WEST SUSSEX COUNTY COUNCIL CONSULTATION

TO:	Arun District Council FAO: Jessica Riches
FROM:	Stephen Gee WSCC - Highways Authority
DATE:	11 July 2022
LOCATION:	Land East of Fontwell Avenue Fontwell
SUBJECT:	WA/56/22/PL Variation of condition imposed under WA/48/19/RES relating to condition 1-plans condition to allow an amendment to the non residential floorspace building at the entrance to the site (Block A) and the provision of 5 No new flats. This site also lies within the parish of Barnham and Eastergate.
DATE OF SITE VISIT:	n/a
RECOMMENDATION:	More Information / Modification
<u>S106</u> CONTRIBUTION TOTAL:	£5,000 per dwelling

The application is for the provision of 5 additional flats and removal of an element of non residential floorspace within the Land East of Fontwell Avenue strategic development.

Drawing No: 4736/DAN/RET/06F

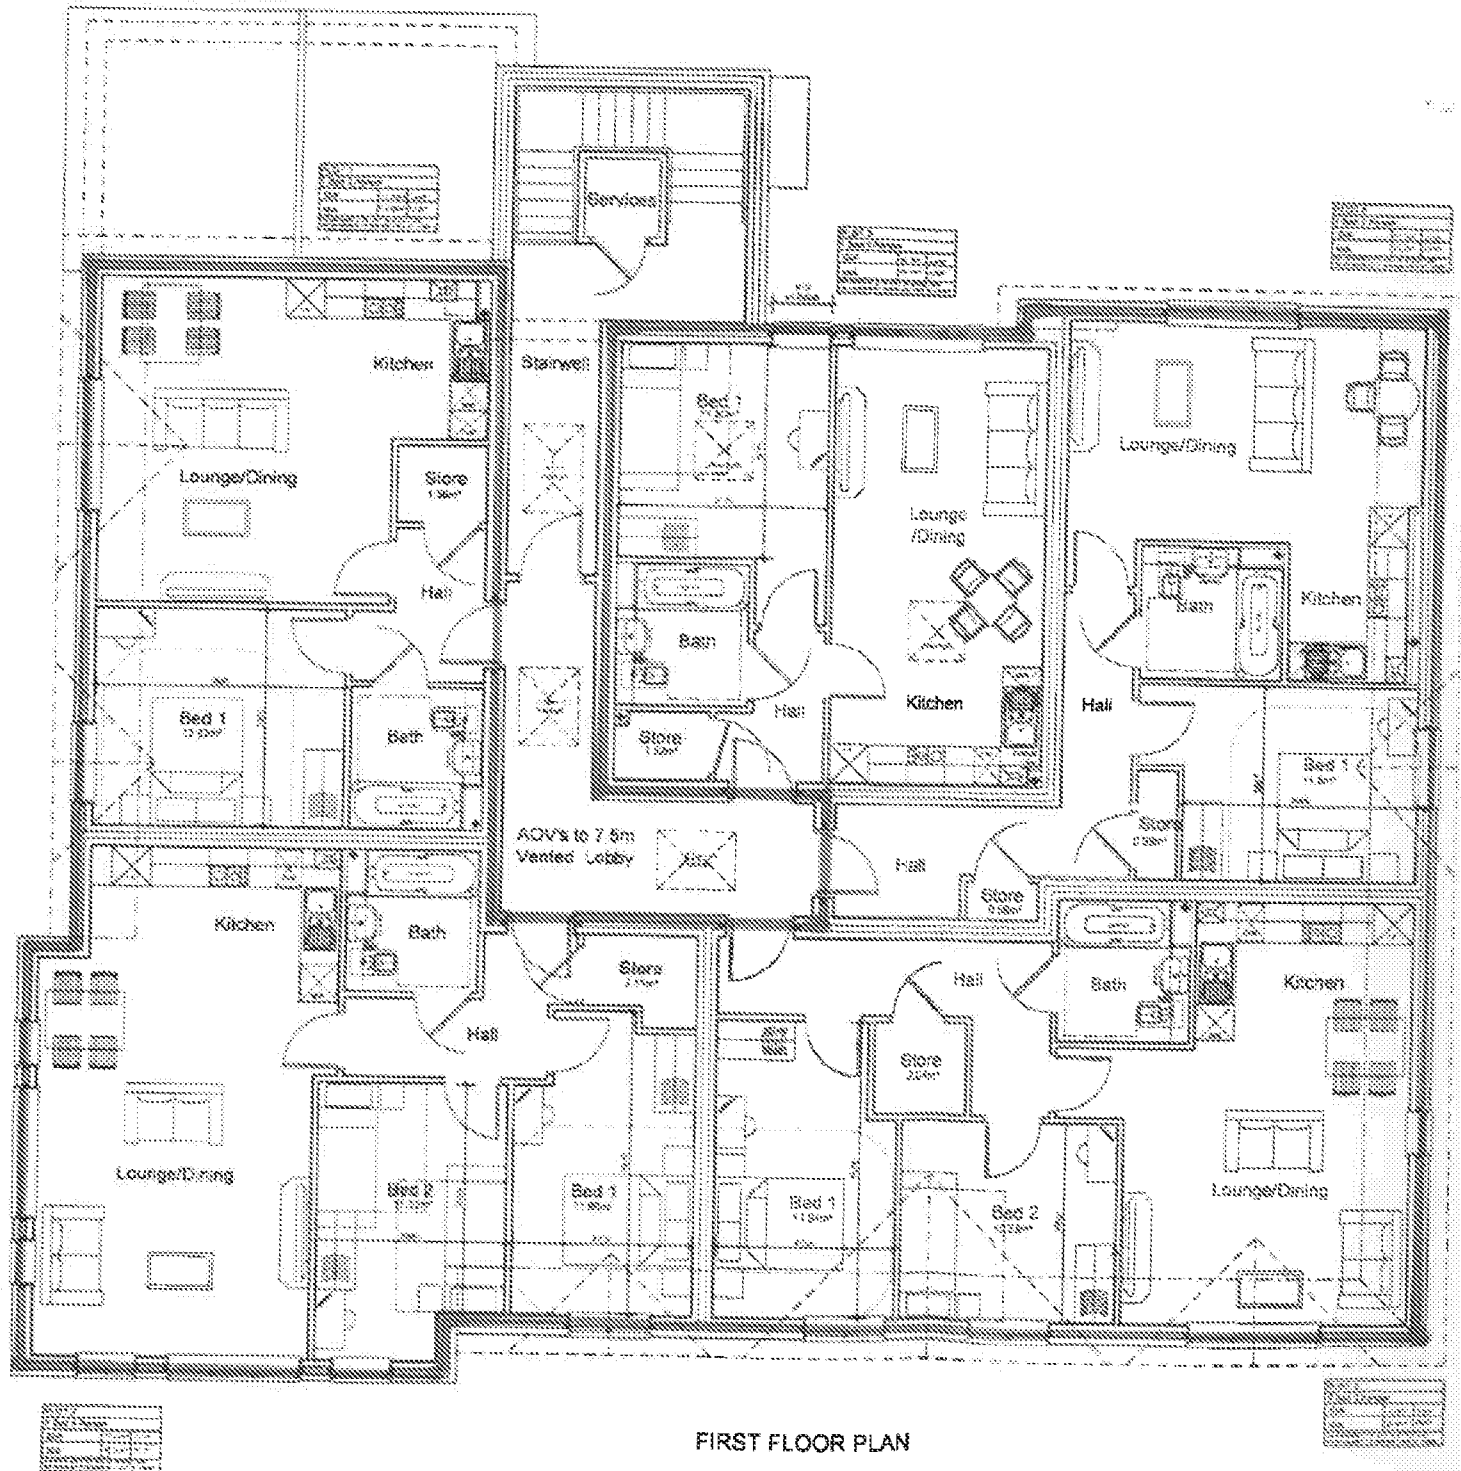
No details on cycle parking for the units have been provided and the cycle parking spaces for the retail store appear to have been removed.

Additional information/modification is requested upon the level and location of cycle parking for the residential units and retail store and if the retail store car park would have any parking restrictions.
